Single Family and Street Construction

#2012-471

RE: Staff Review Comments for Single Family and Level II Site Plans

Project Name: Pomeroy Street Single Family Home & Street Construction Project ID: 2012-471
Applicant: Chabad Lubavitch of Maine, Inc. CBL: 193-E-1
Planner: Nell Donaldson

CURTAIN DRAIN
 N.T.S.
 (FOR DITCH SECTIONS ONLY-SEE PLAN)

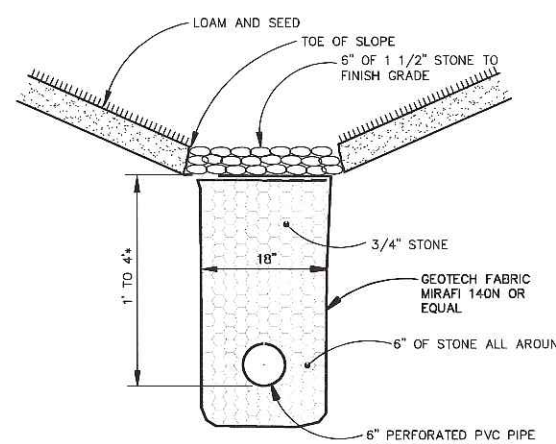
As designed, the roadway cross slope transitions to the curtain drain inslope (3:1) along the eastern edge of the road with no shoulder to back the pavement. The design should include at

minimum a 12" shoulder to back the pavement edge. The loam & seed inslope to the curtain drain should either be sodded or should include a temporary erosion control matting to prevent erosion of the loam into the curtain drain.

The design should include an inlet (catch basin or area drain) at the end of the curtain drain, approximately STA 0+15, where the drain has an angle (elbow). The inlet will allow for a clean out at this transition and will provide a high-flow inlet into the system. The design should include a cleanout riser at the top of the curtain drain, approximately STA 2+00. The pipe crossing Pomeroy Street from the end of the curtain drain to the existing catch basin in Bancroft Street should be 10" solid pipe (pipe material meeting City Technical Standard 2.5.2).
